Ref:
SSD-82709458

RE: SUBMISSION TO SSD-82709458, Residential development with infill affordable housing
Address: 19-25 Balfour Street, Lindfield

Ku-ring-gai Council's objection to SSD- 82709458, 19-25 Balfour Street, Lindfield

1 **OVERSHADOWING - 11AM JUNE 21 (EXISTING)**
1 : 1000

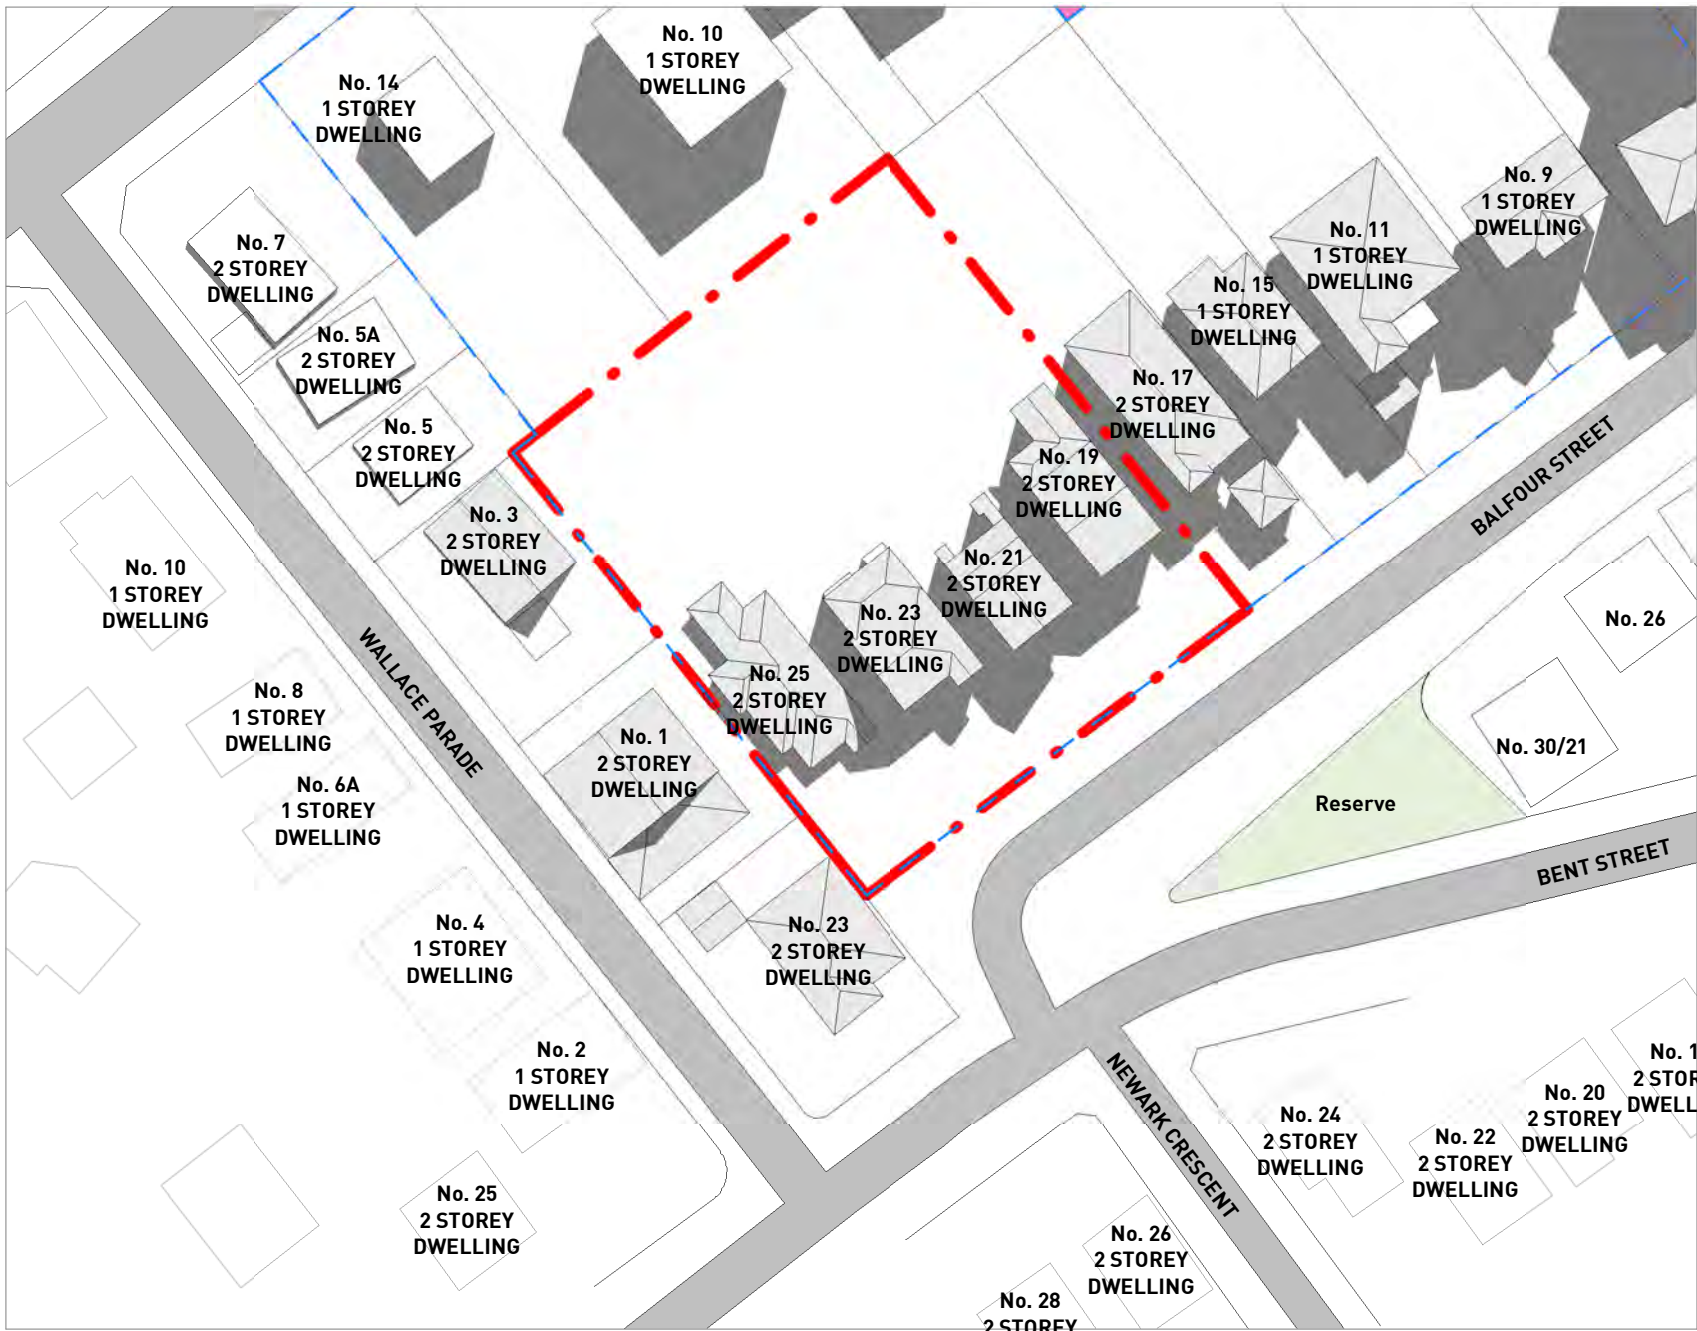
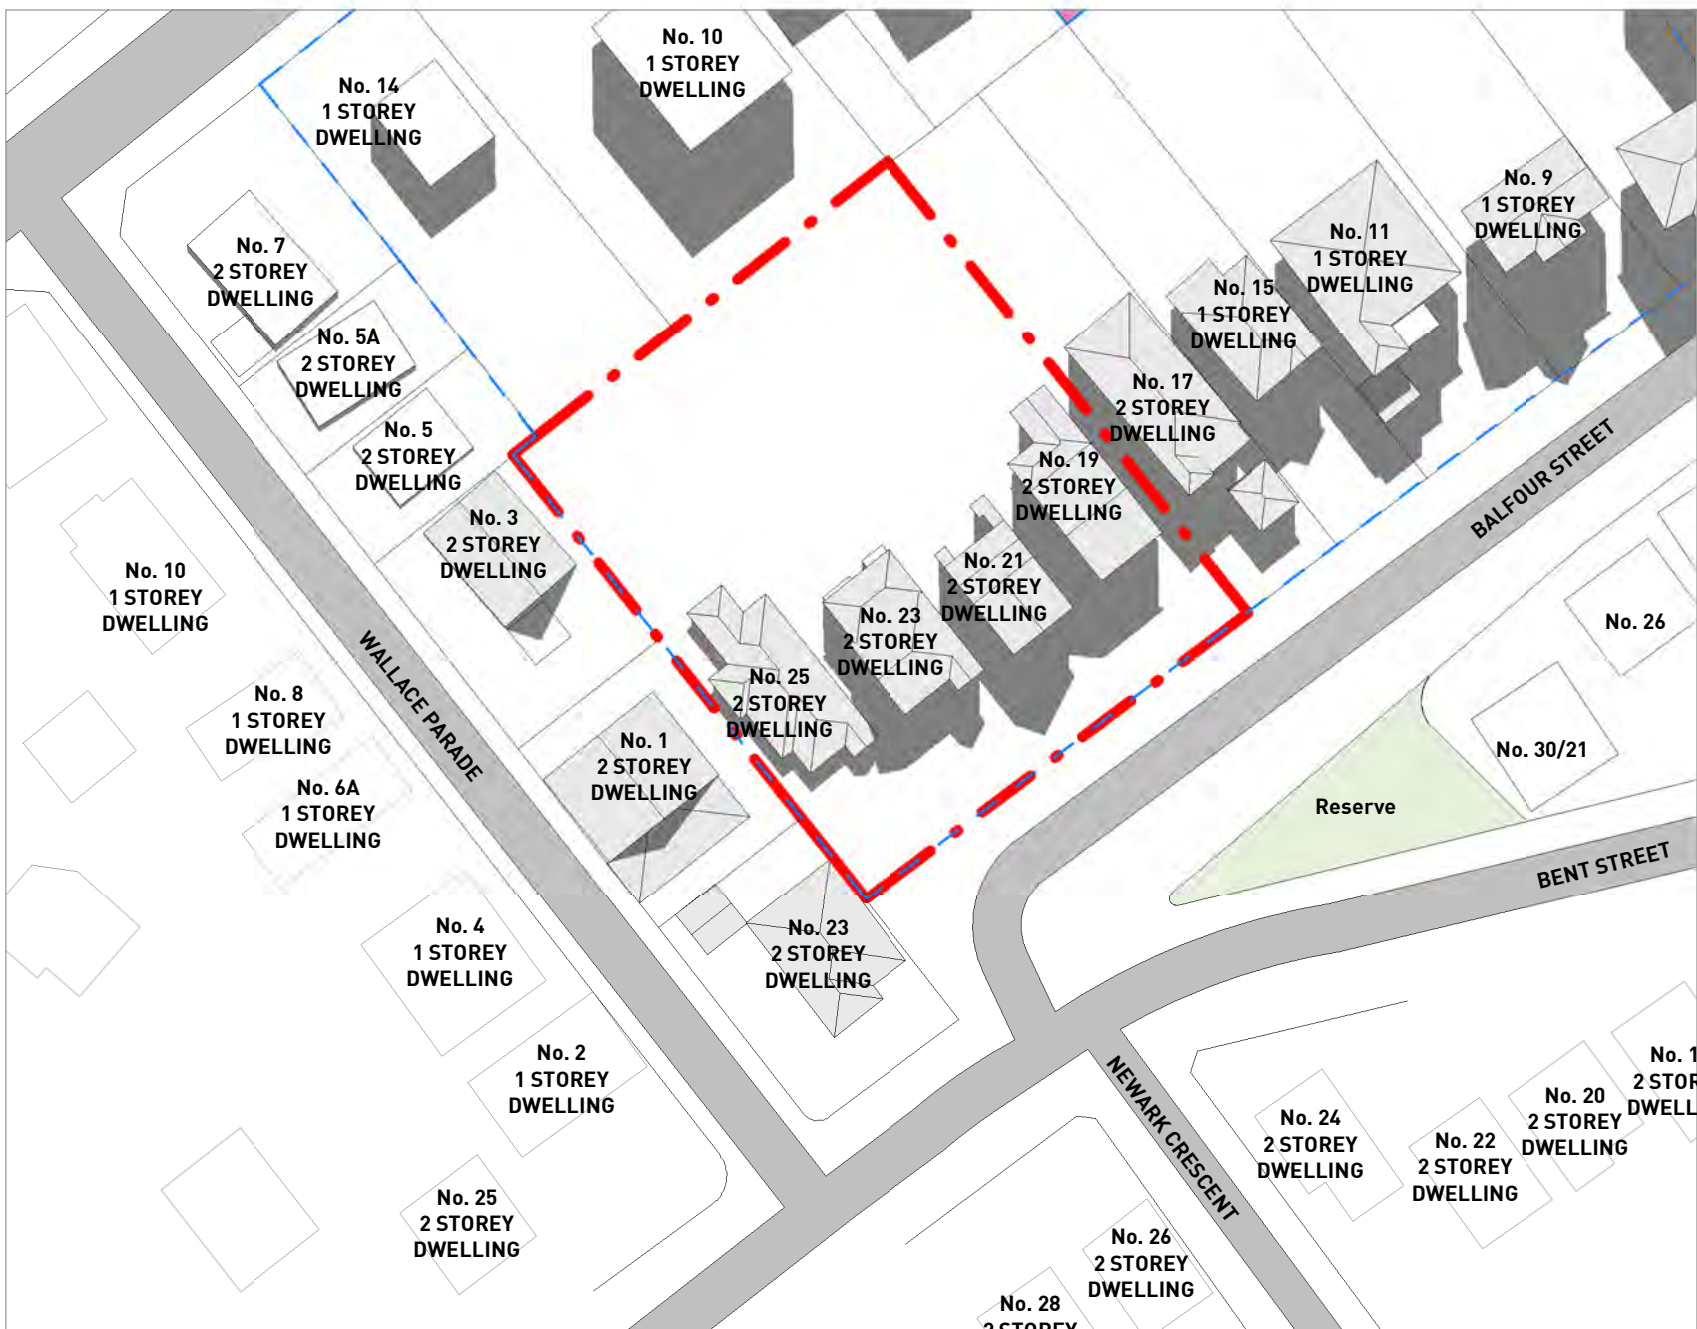
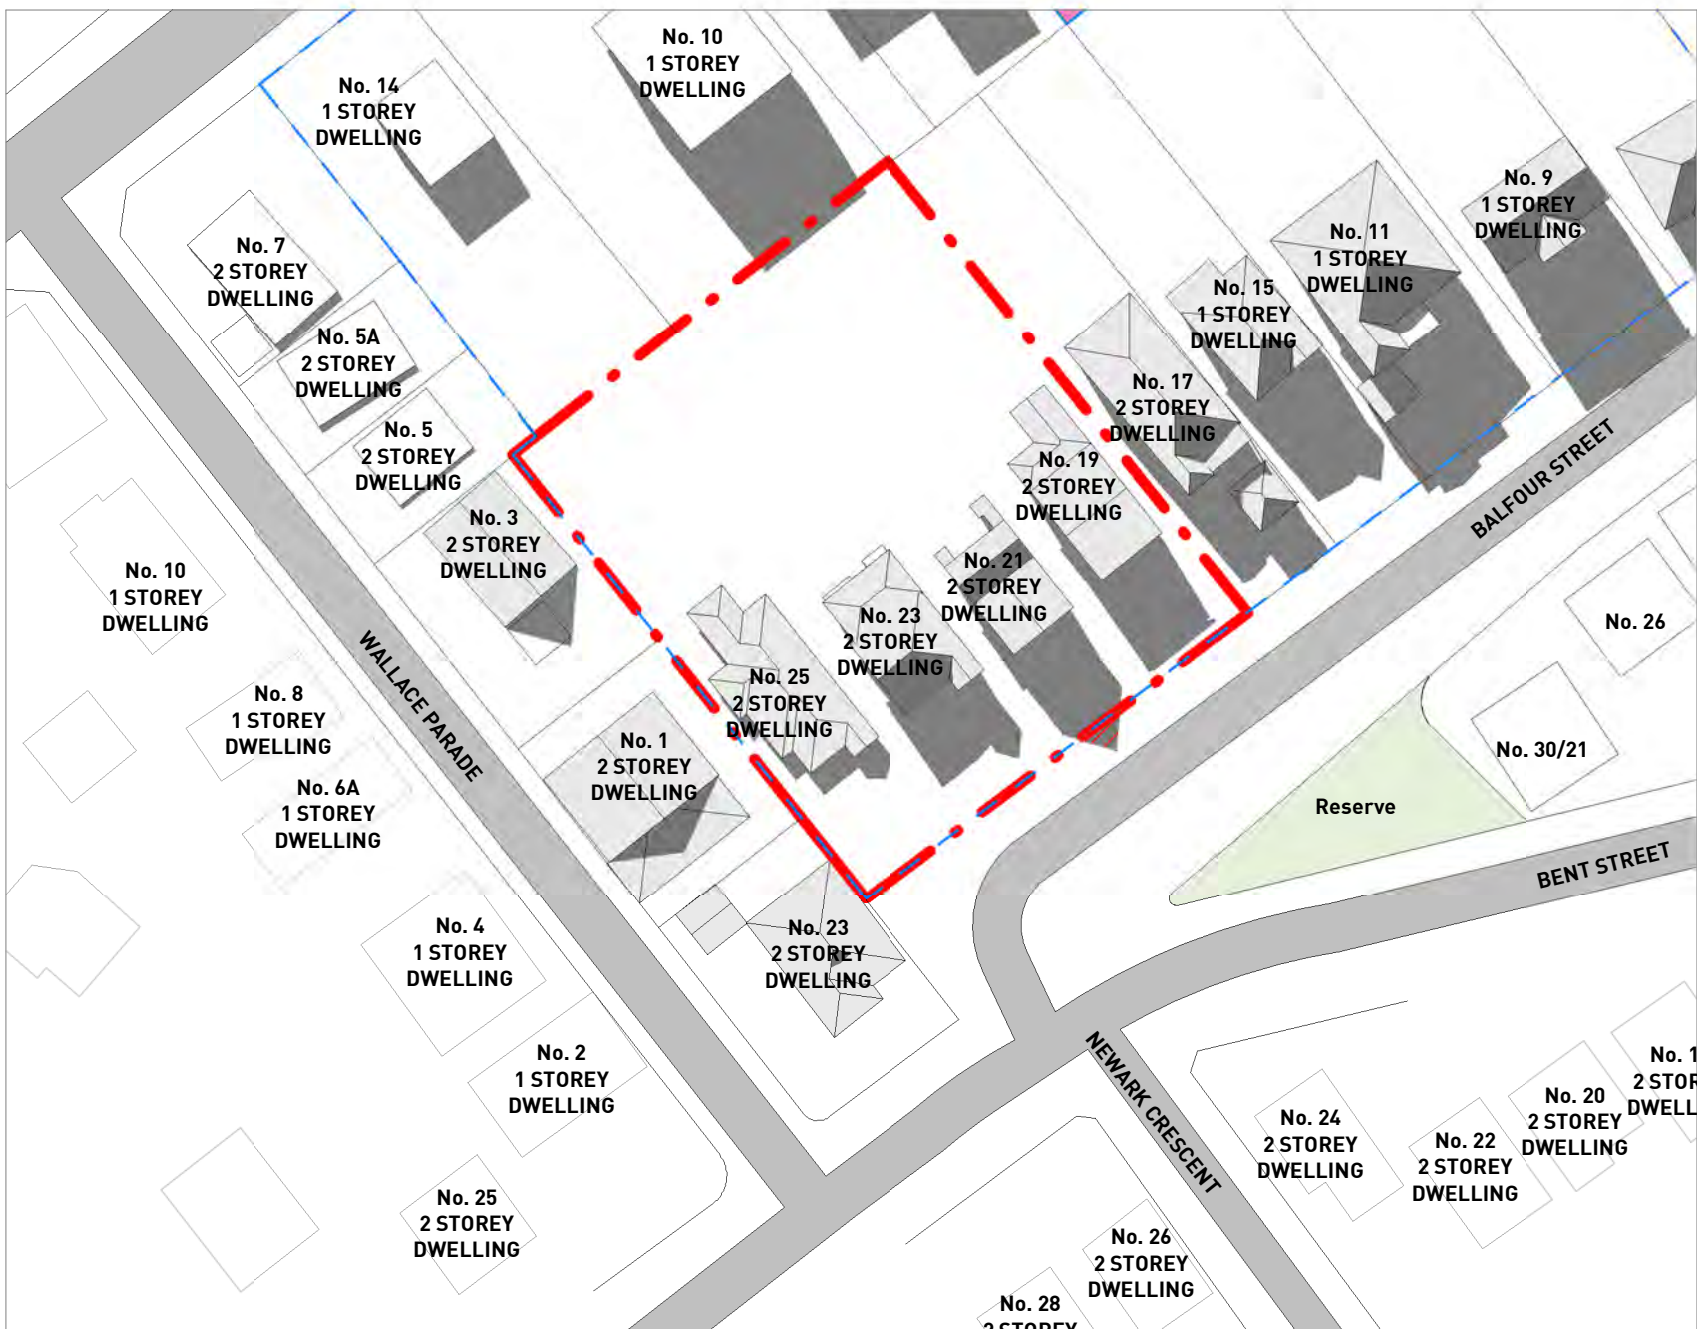
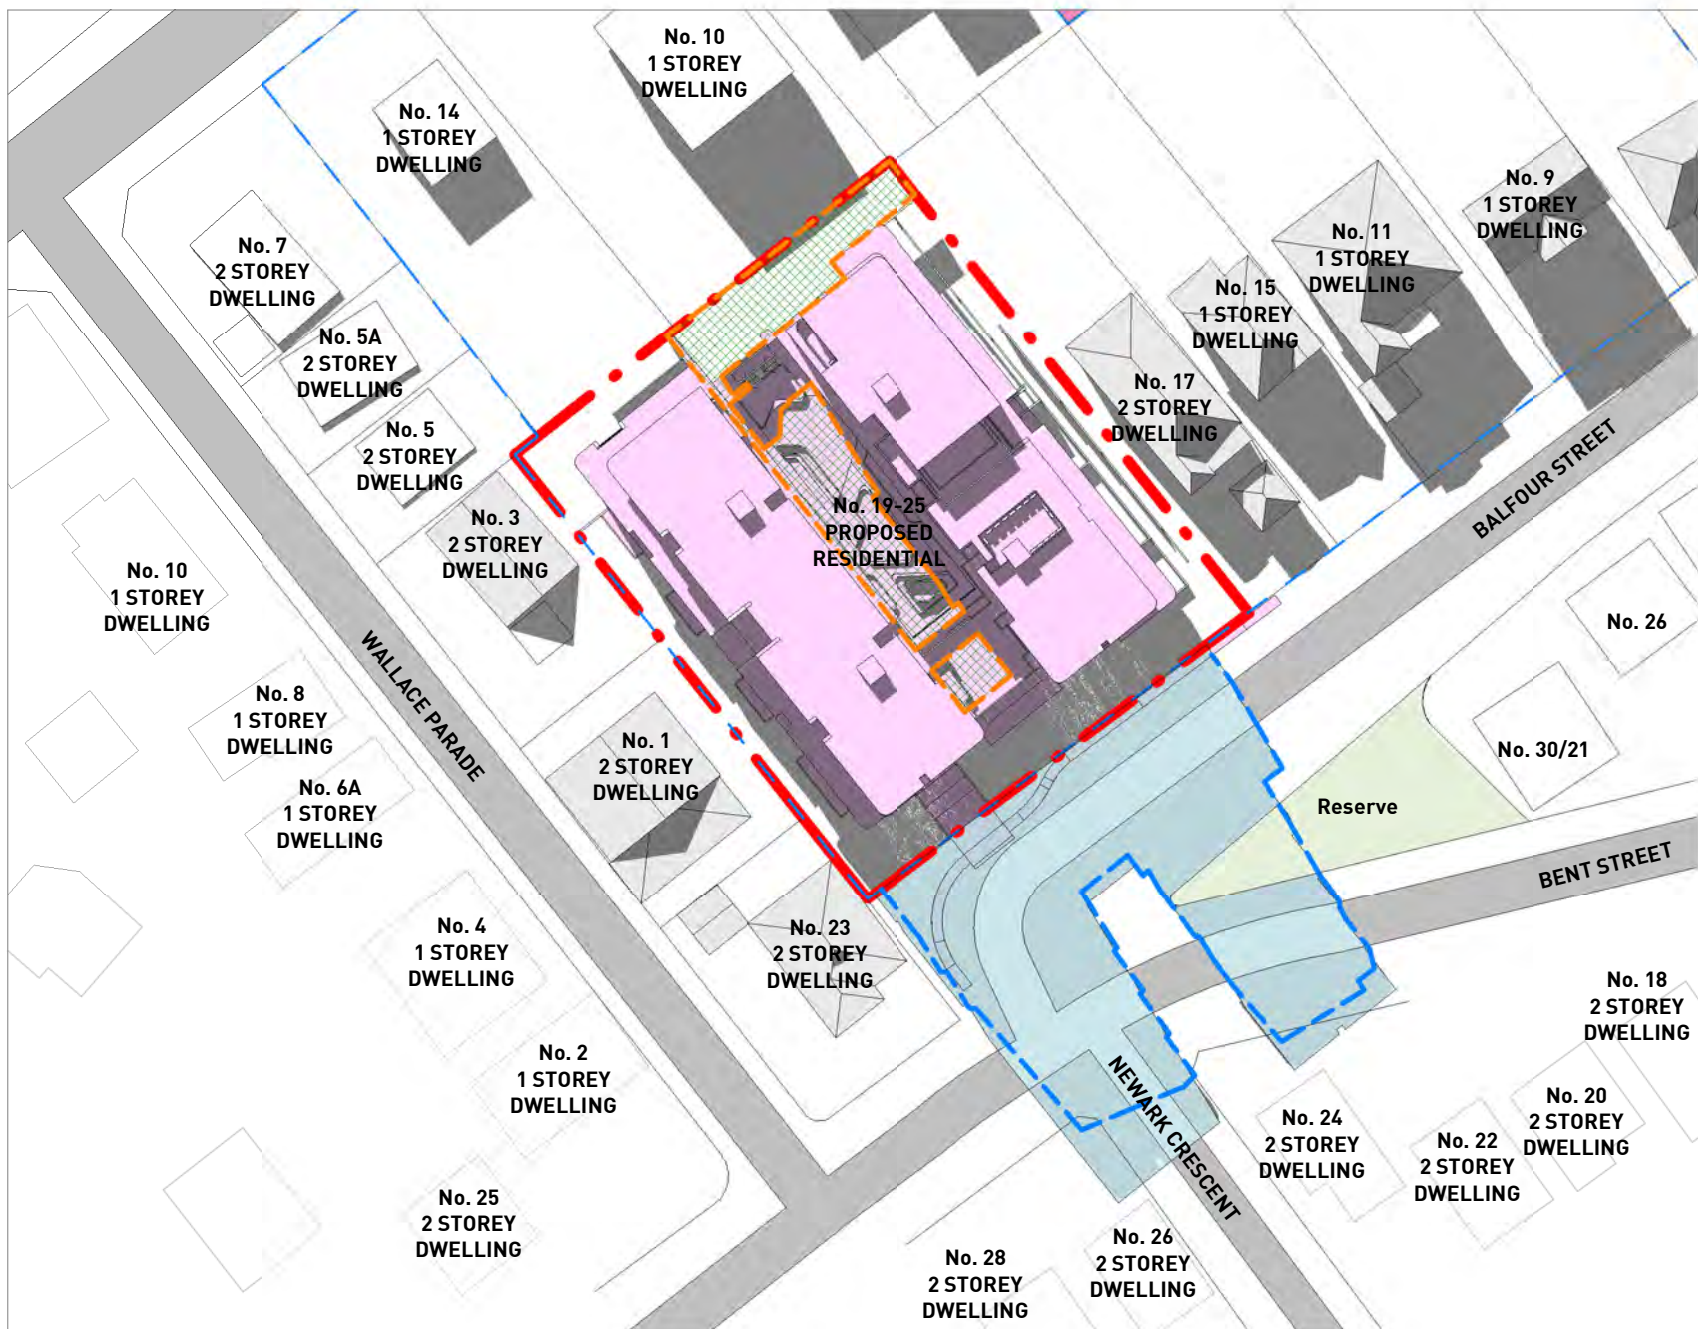
The site slopes to the south-west, exacerbating overshadowing impacts on neighbouring properties. The dwellings at 23 Bent Street and 1 Wallace Parade are in partial or full shadow until 2pm, leaving only one hour of sunlight (2–3pm). This represents a significant shortfall in solar access relative to the ADG's objectives. Importantly, the proposal does not comply with setbacks along the western elevation at the 10 storey and makes no provision for increased separation or setbacks to the west, despite the ADG guidance that these measures should be applied where overshadowing impacts are significant.

The In-Fill Affordable Housing Practice Note (p.12) clearly states: *"The full extent of the in-fill affordable housing bonuses may not be achieved on all sites, due to site constraints and local impacts. The in-fill affordable housing bonuses should not be treated as an entitlement."* Despite this, the submitted Overshadowing Diagrams compare shadows cast by a so-called 'compliant height' form with those of the

proposed scheme. However, the 'compliant' form is taken to be 26.86m, already assuming the affordable housing bonus. This methodology understates the actual impacts, as a true and accurate comparison should be between the 22m control and the proposed scheme.
